1 April 2019

Our Ref: 16-0011Lcmc1

Re: One Carrington Street Project Section 4.55 Application (s4.55)—Shell House Margaret Street Base Course—Heritage Impact Assessment

drawing Proposed Shell House Elevations

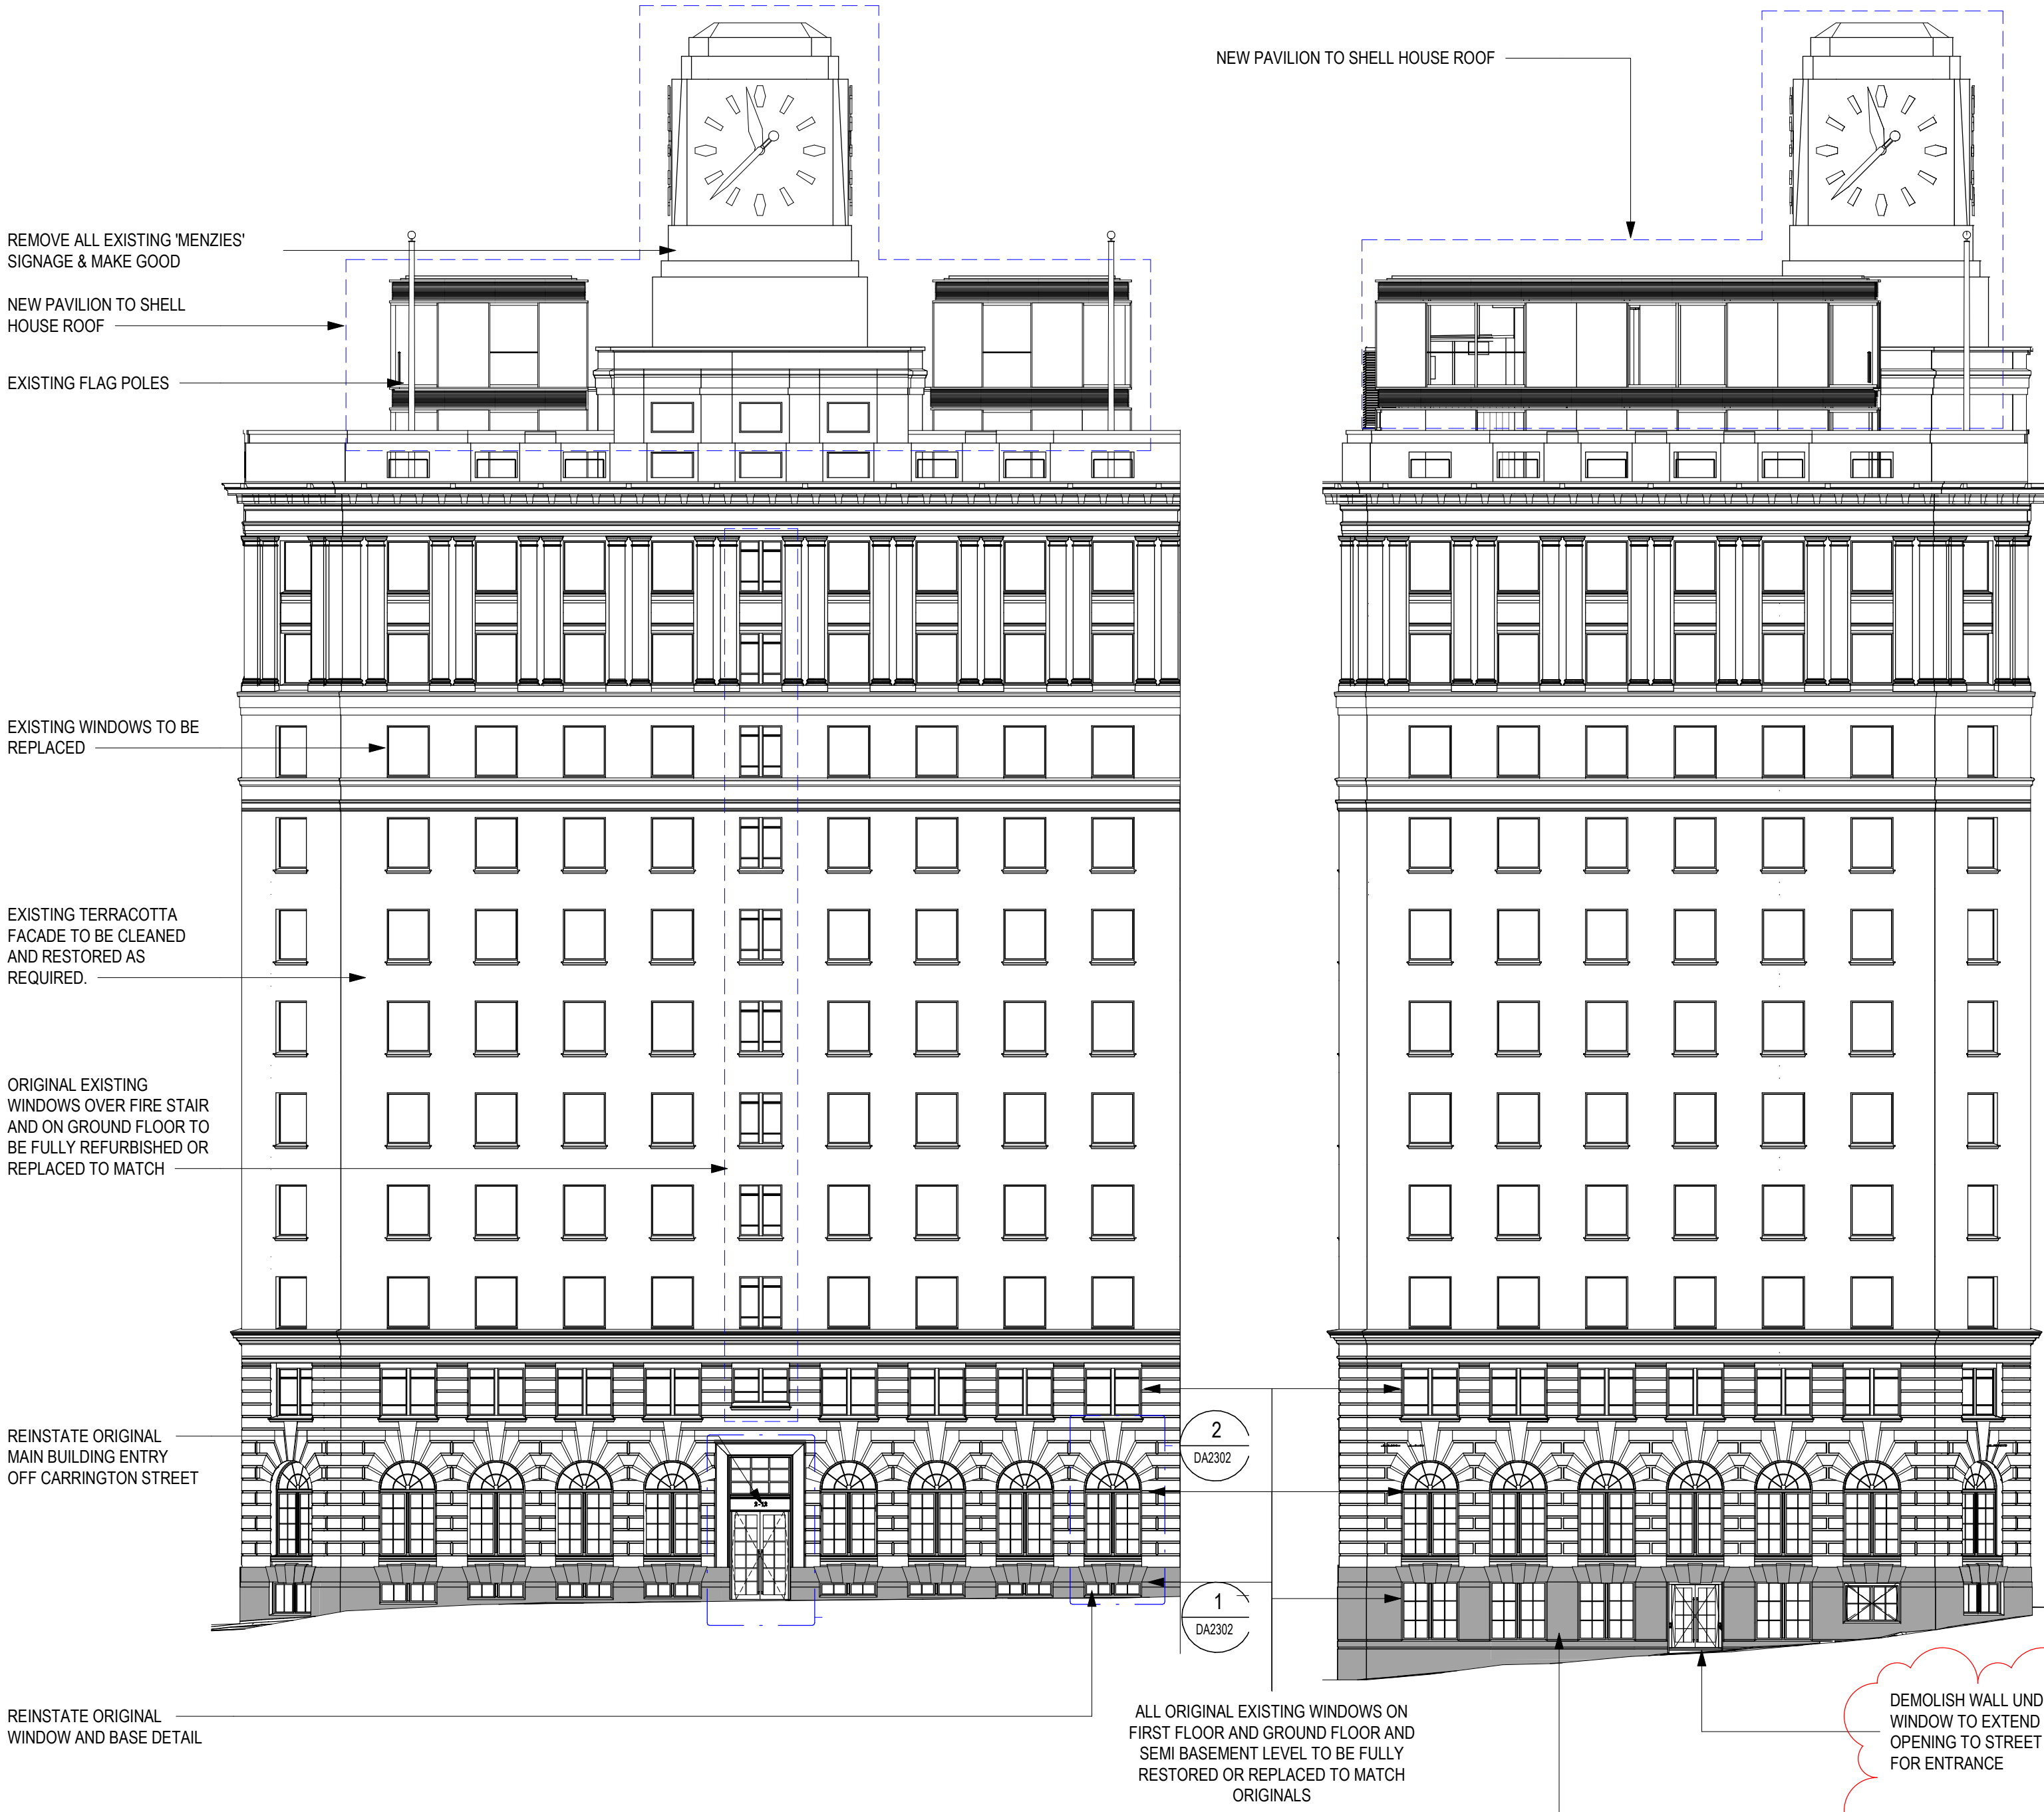
- removal of the intrusive 1978 Margaret Street service entry and recreation of a pair of windows to the rhythm and detail of the original design, noting that originally there was a window and a door in this location;
- adaptation of an existing original window opening to create a new doorway to the new basement level, including removal of the trachyte base to provide at grade access;
- new installation of new steel frame multipane windows to match the original windows in this location, in conjunction with reuse of salvaged original steel frames where feasible; and
- new work to create or alter openings will utilise salvaged trachyte where possible.

Attachment C includes Figure 4, an extract of the architectural drawing of Shell House Margaret Street, showing the current proposed configuration, as well a Figure 5, a detailed elevation, showing the revised levels of the basement.

Positively, this proposal demolishes the intrusive 1978 service entry to Margaret Street, and recreates the architectural rhythm and design intent of the trachyte basecourse. The 2016 s.96 approval included removal of the entry previously.

The minor adverse impact of the proposed new doorway, which involves modification of an original window, is offset by the deletion of a similar window that was previously altered for a fire panel access two bays to the west on the same elevation (2016 s.96 approval). The new doorway will utilise the materiality, pattern and detail of the original windows and doors.

Overall, this proposed modification respects the architectural rhythm and detail of the building and its trachyte plinth course and will not result in any adverse heritage impact on Shell House.

This change is considered acceptable in heritage terms, subject to the detailed design resolution being carefully undertaken with due utilisation of the materiality, pattern and detail of the original windows and doors. Measures to ensure a satisfactory outcome for the building are outlined in the recommendations below.

- Detailed design of the Margaret Street plinth course changes should ensure that the relevant heritage conditions of the Concept Plan Approval Schedule 3, as well as any heritage requirements of subsequent approvals, are met.
- The detailed design of the new doorway proposed to replace the original steel framed window dating from 1938 on the Margaret Street frontage, and the pair of windows already converted into a service door, should consider and utilise the materiality, pattern and detail of the original windows and doors.
- Specialist heritage advice should be incorporated into the detailed design and construction phases to guide works to the Margaret Street plinth, in particular for the recreation of openings, the use of salvaged/new trachyte (or use of other materials). A stonemason experienced in the repair and replacement of trachyte should carry out the work.
